Recommendation Report for

REF NO: A/83/20/PD

LOCATION: 1 Marsh House
The Square
Angmering
BN16 4EA

PROPOSAL: Prior notification under Schedule 2, Part 3 Class C for part change of use from retail home and garden shop (A1) to cafe(A3).

JUNA HOME AND GARDEN
1 MARSH HOUSE
THE SQUARE
ANGMERING
WEST SUSSEX
BN16 4EA

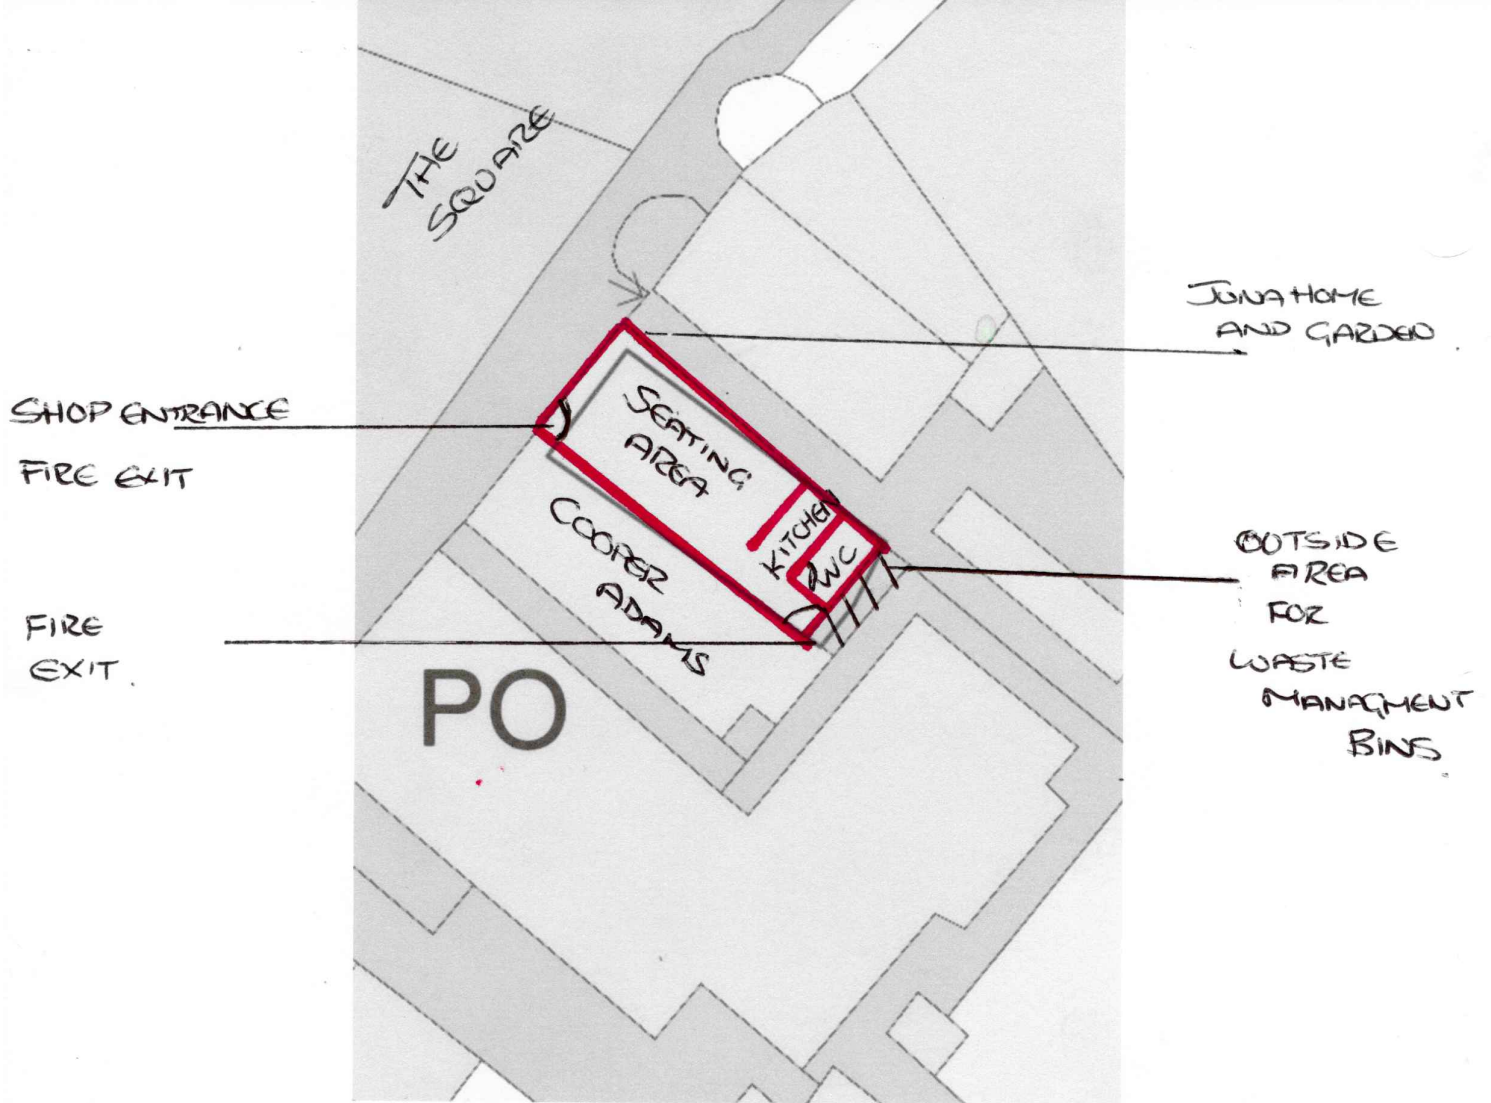
- 8 INFORMATIVE:8.The proposed floor plan currently shows one toilet in the premises. The numbers of toilets required will depend on the number of staff and seated customers proposed. Any customer toilets provided must not be accessed via the kitchen or any food handling areas. Please note the requirements for toilet provision in Arun District which can be found at <https://www.arun.gov.uk/download.cfm?doc=docm93jjm4n11788.pdf&ver=11779>
